A47 Blofield to North Burlingham Dualling

Scheme Number: TR010040

Volume 9 **9.6 Schedule of Changes to dDCO**

Schedule of drafting changes for dDCO Deadline 5

DRAWING TITLE  
**CLASSIFICATION OF ROADS PLANS REGULATION 5(2)(o) SHEET 2 OF 8**

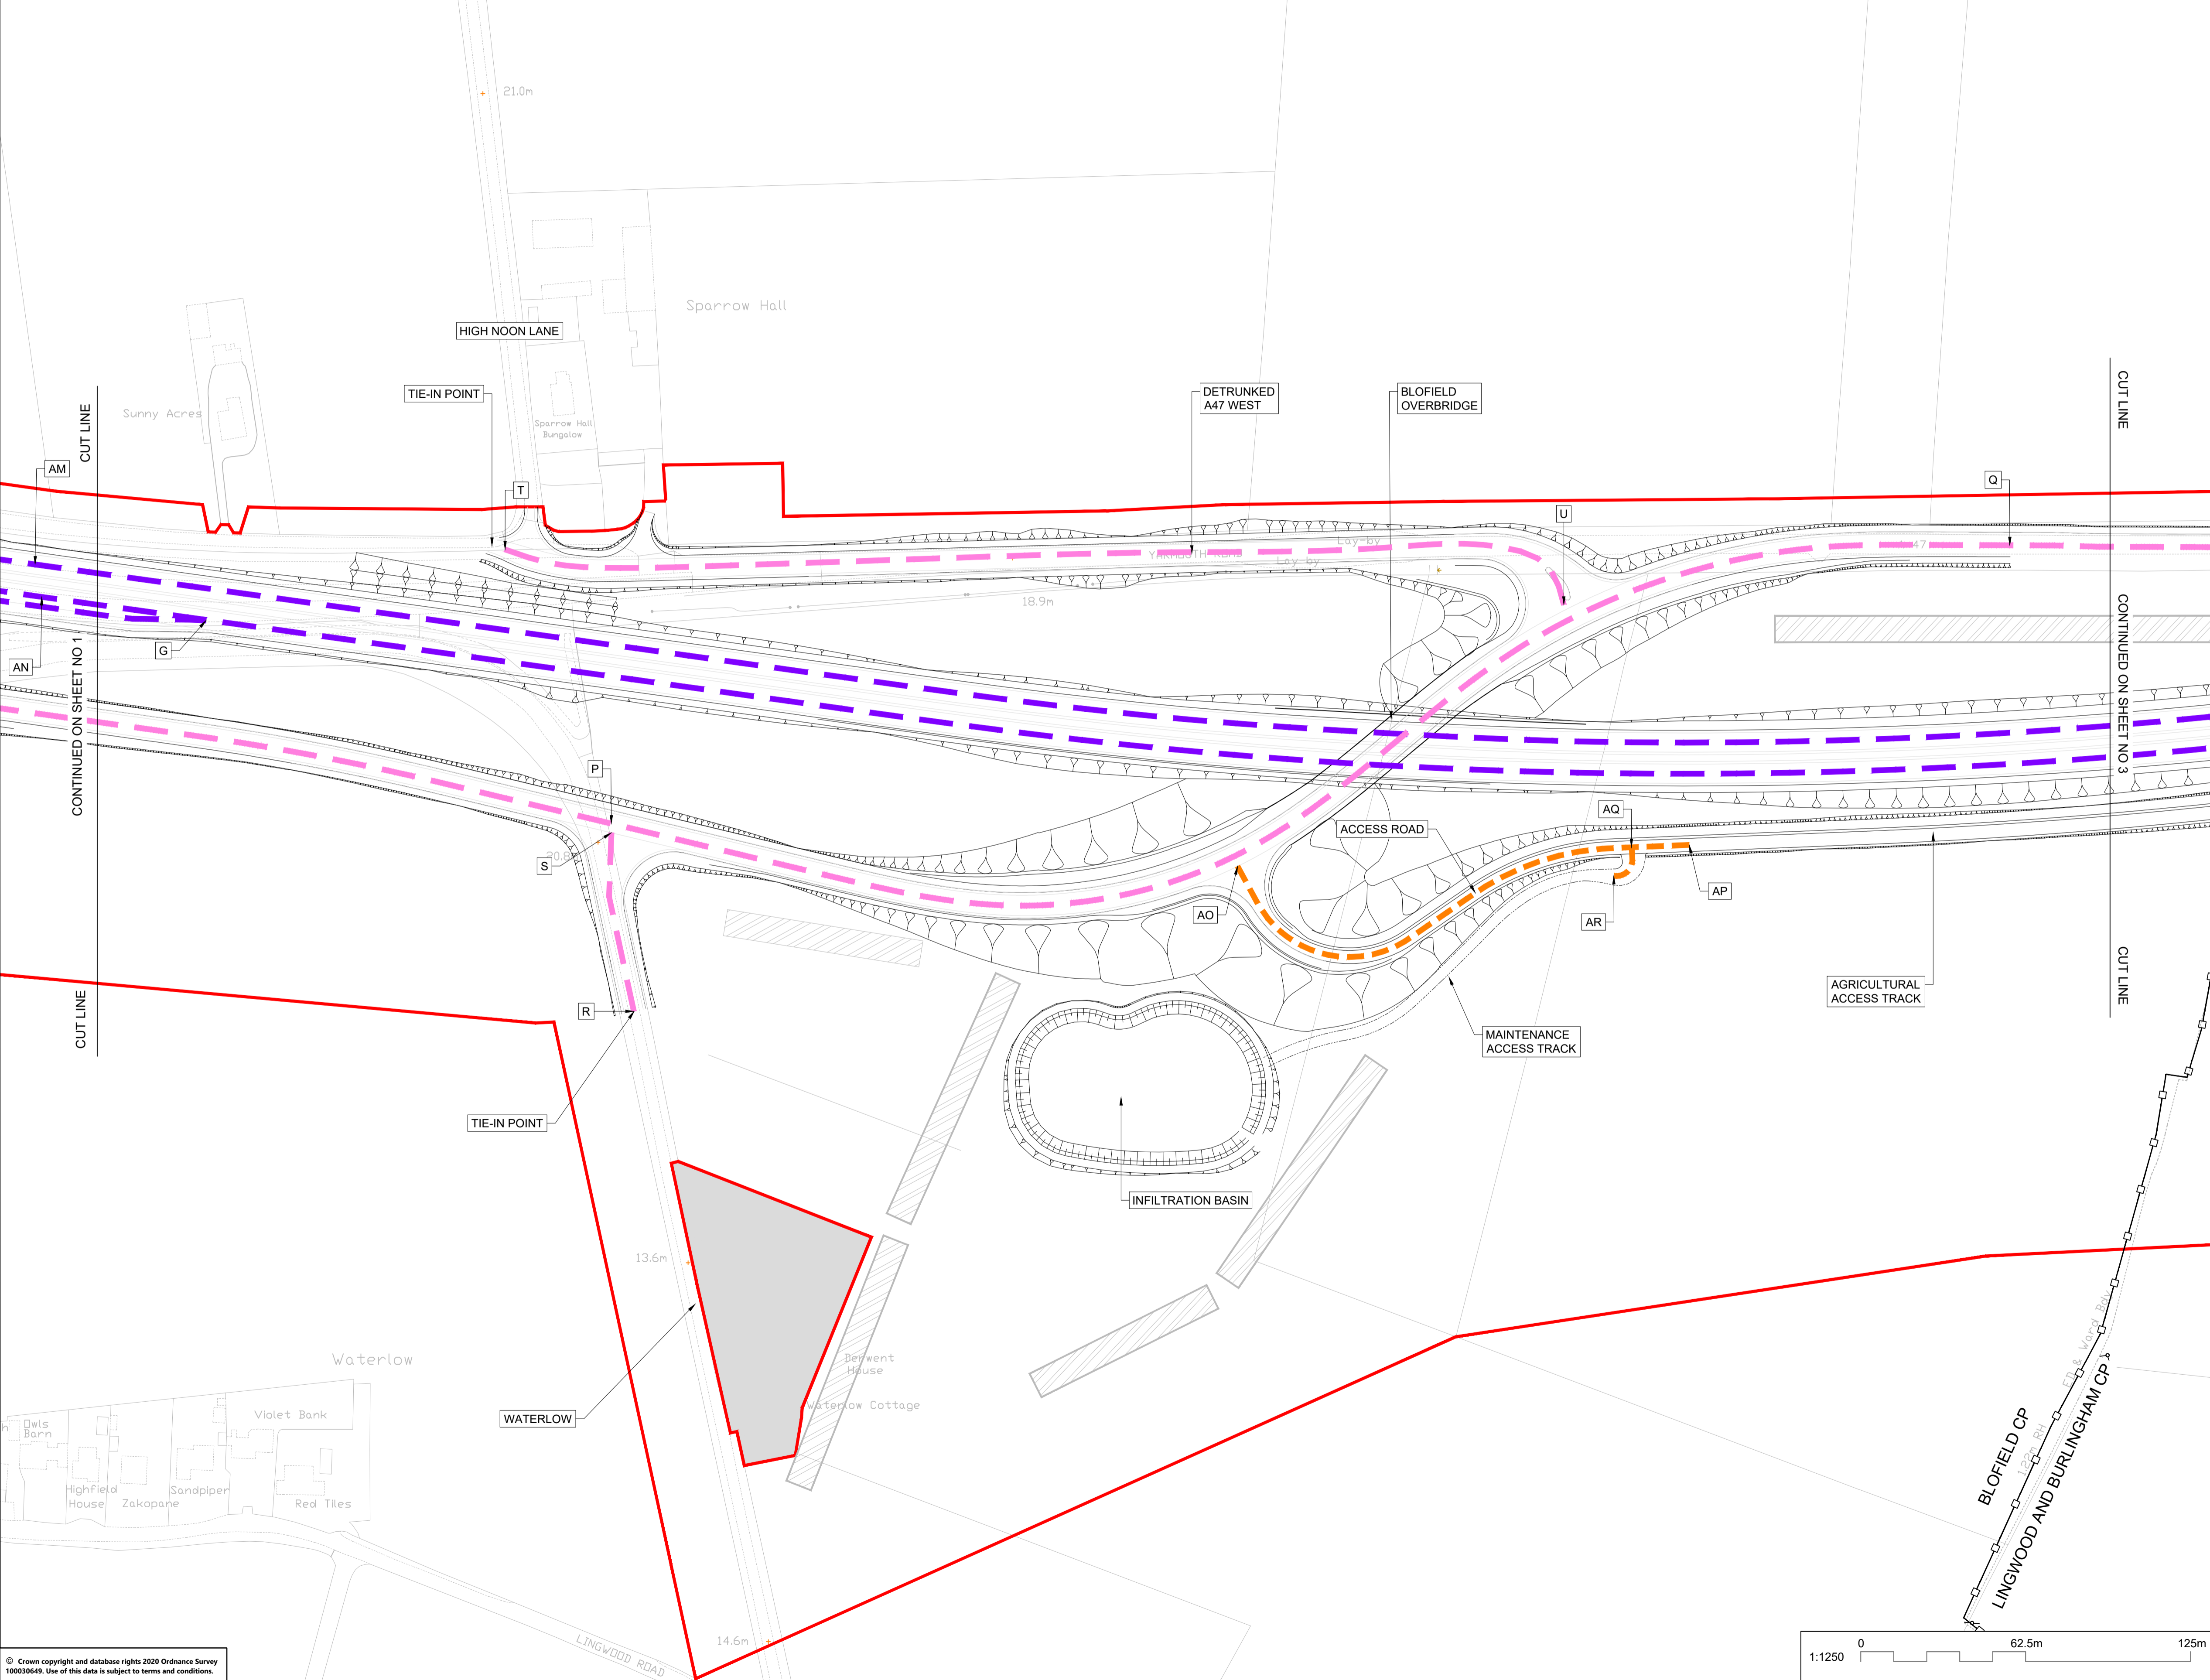
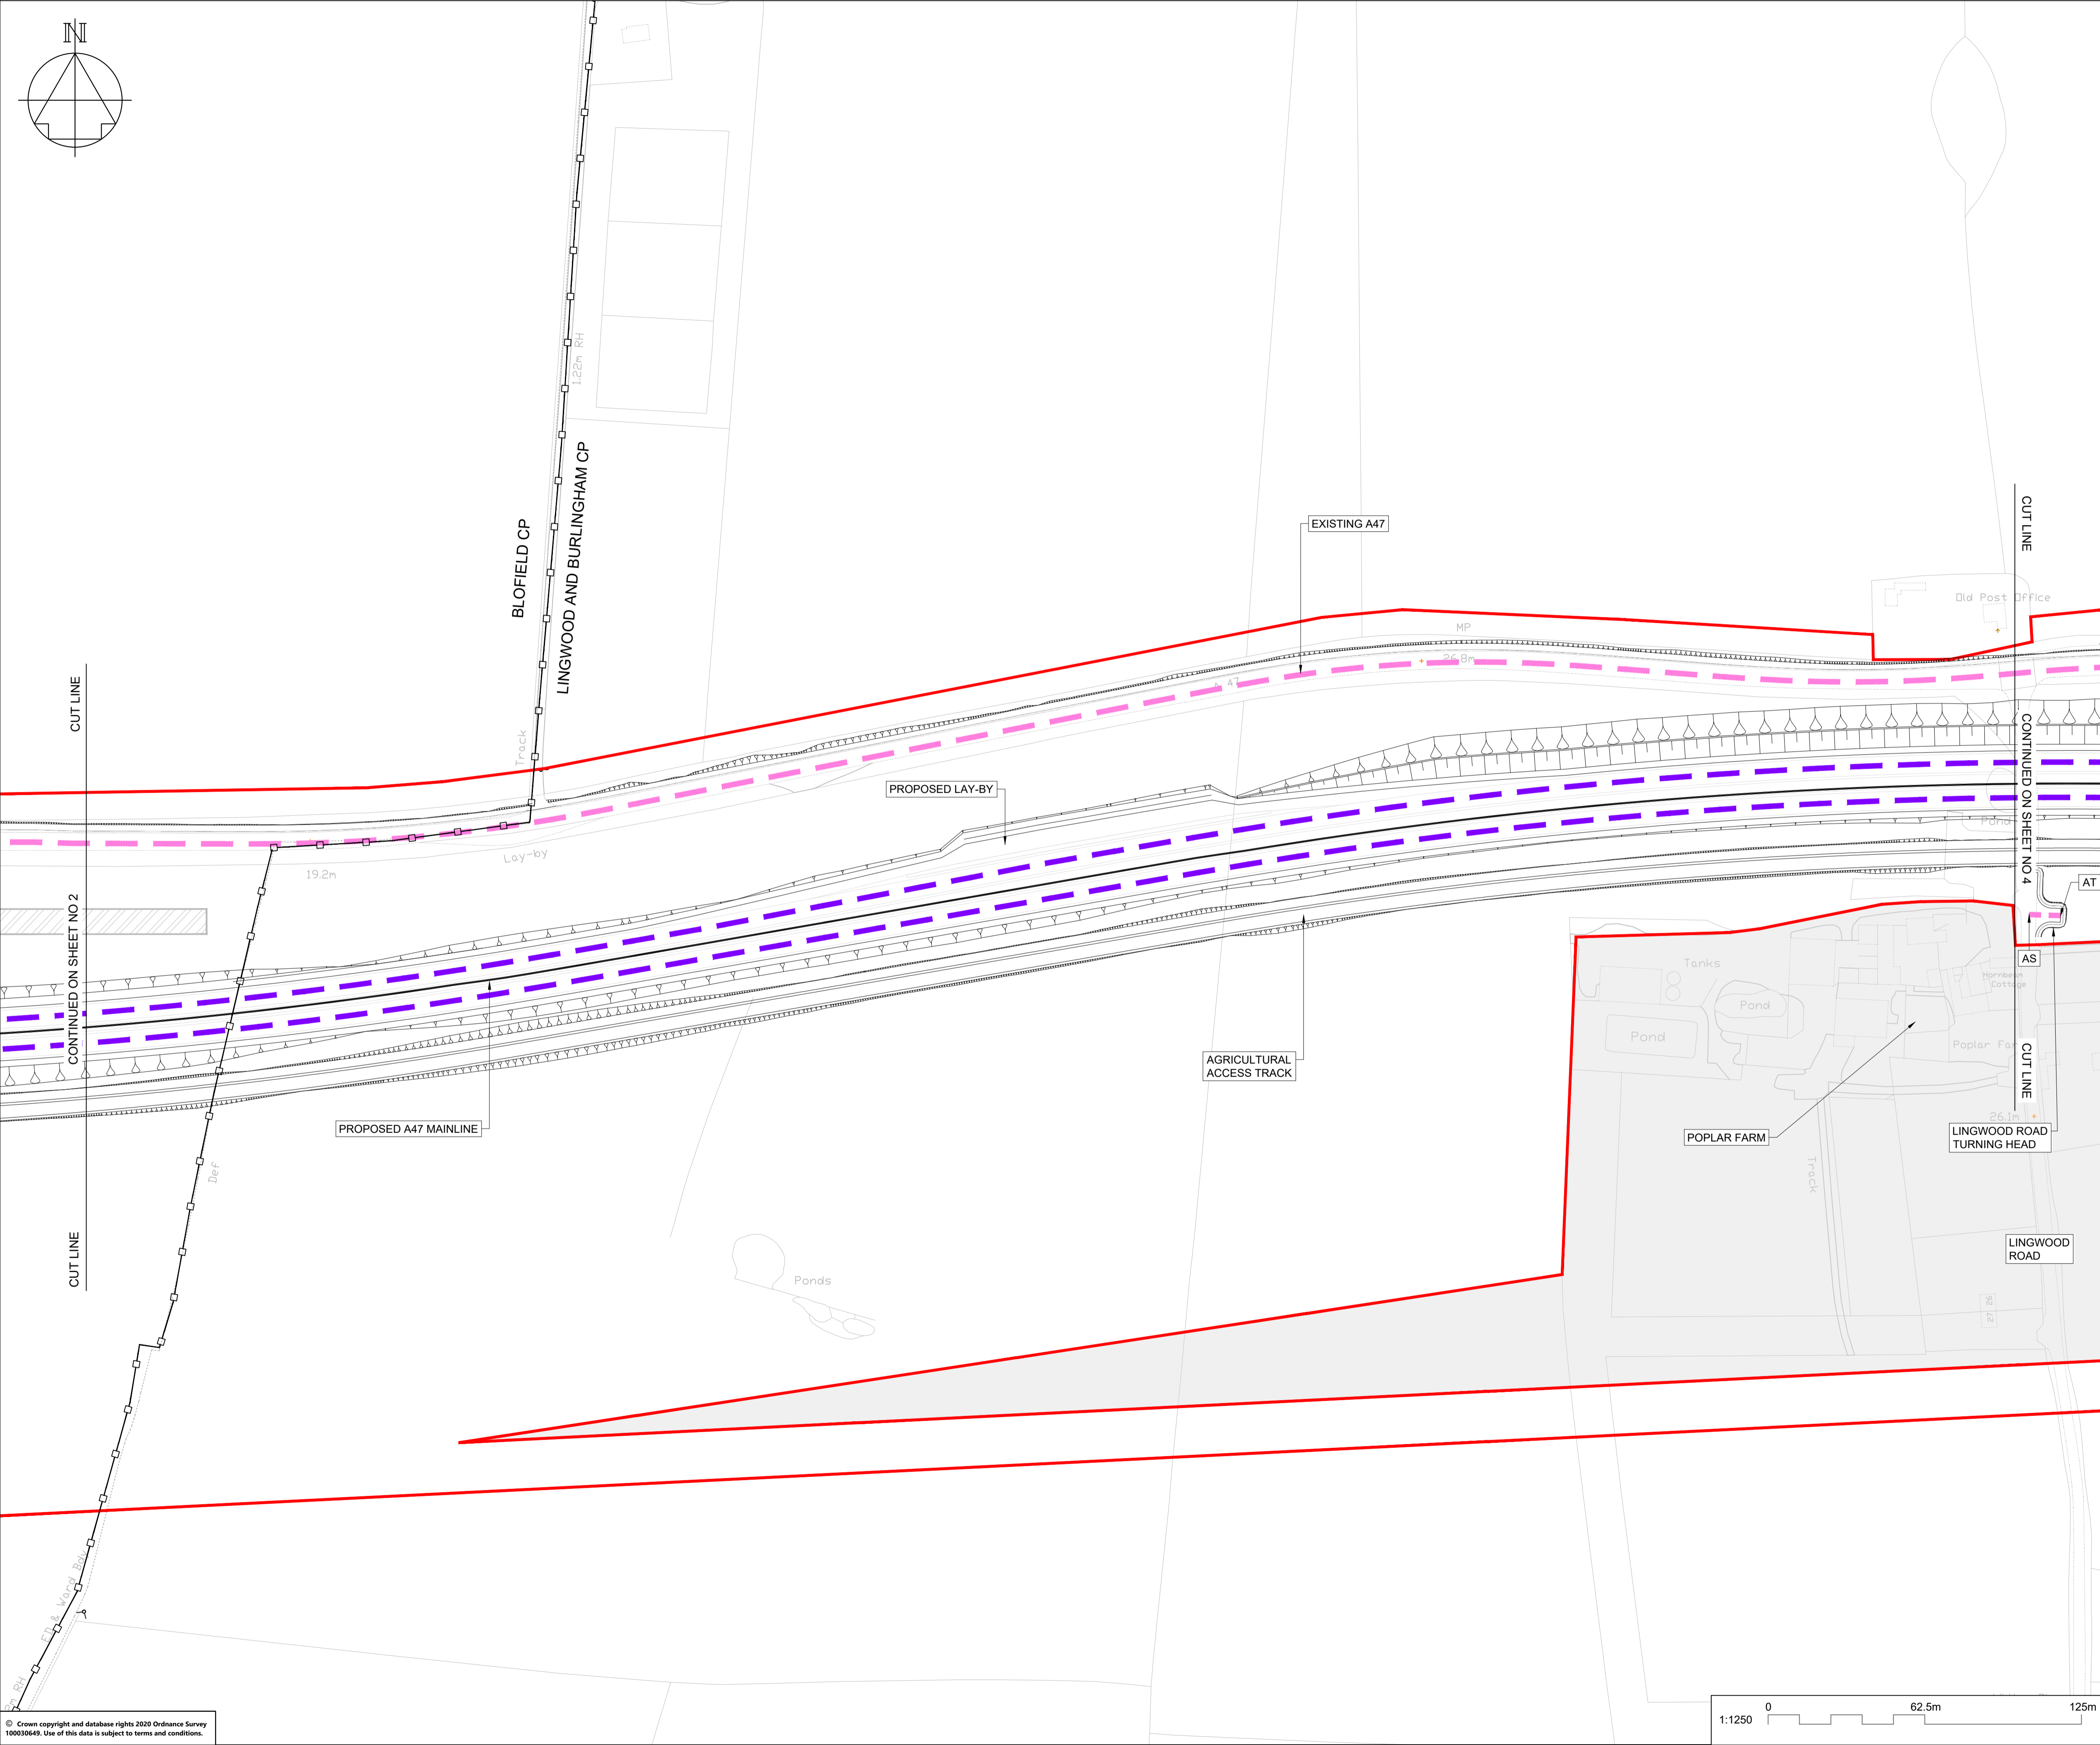
Schedule 3 ' Classification of Roads, etc' Part 1: Trunk Roads	A new row under the title "The classification of roads plans – sheet 1" (1) In column (1) the word "Blofield" (2) In column (2) a description of the new length of classified road:	This road appears on the classification of roads plans but was not included in the Schedule in error.	N/A	N/A

Article/Schedule	Change	Reason for change	Precedent used	Consequential changes
	<p>"Yarmouth Road Junction Westbound Diverge (including existing highway to be improved) to be classified as part of the A47 Trunk Road</p> <p>From point E, 758 metres east of the centreline of the Plantation Road Overbridge, in a north-easterly direction to point G (sheet 2) a distance of 162 metres"</p>			
<p>Schedule 3 ' Classification of Roads, etc'</p> <p>Part 6, 'Footpaths, cycle tracks, footways and bridleways',</p>	<p>Under the heading "The rights of way and access plans – sheet 2" the amendment of the second row to:</p> <p>(1) Replace references to F5 and F6 with SU16 and SU17 respectively.</p> <p>(2) Delete the word "footway" and substitute the word "cycle track".</p>	<p>This amendment is required to reflect the proposed change of footpath south of the new A47 to a cycle track. This change is to address comments made by Norfolk County Council and other interested parties during the examination.</p>	<p>N/A</p>	<p>N/A</p>
